THE SOD GUY - SALES LOT

SITE DEVELOPMENT PLANS
LOT 1, APPALOOSA HIGHWAY 24 SUBDIVISION

Site Development Plan_v1-redline.pdf Markup Summary

TRASH ENCLOSURE ELEVATION
 SCALE: 1/2" = 1'-0"
 0" 1" 2" 4"

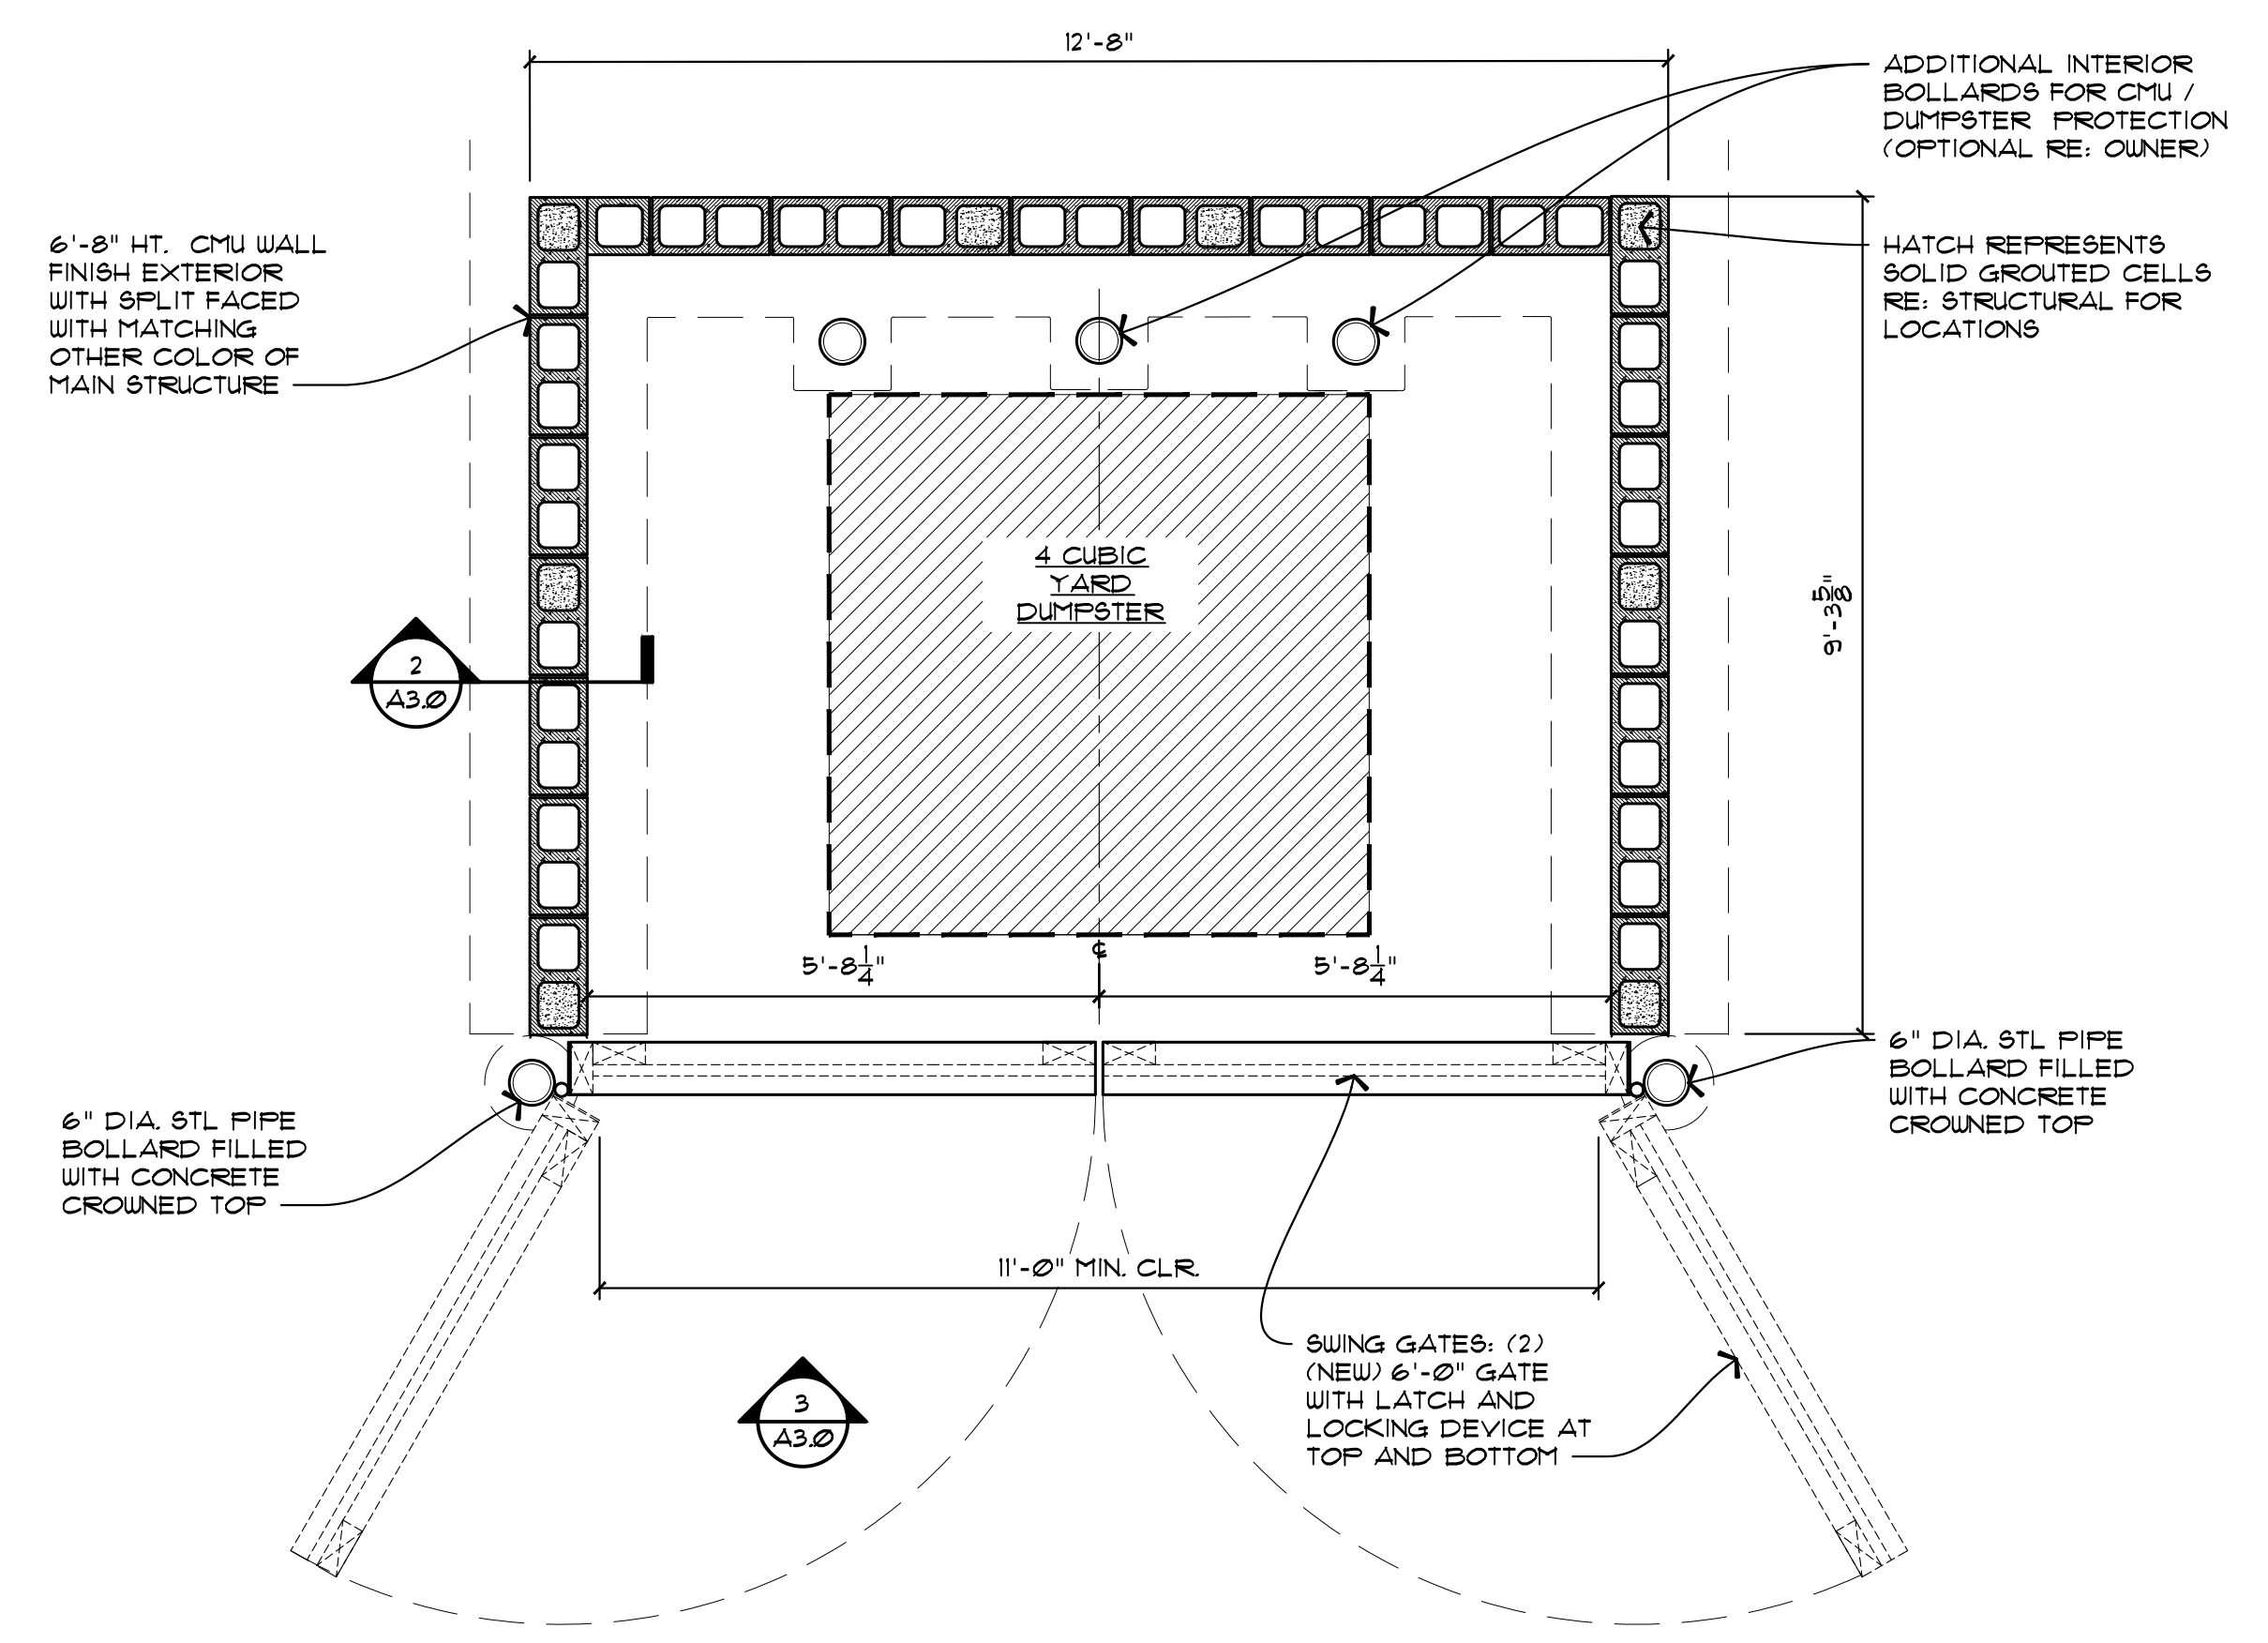
Show fence detail.

Show trash enclosure and detail.
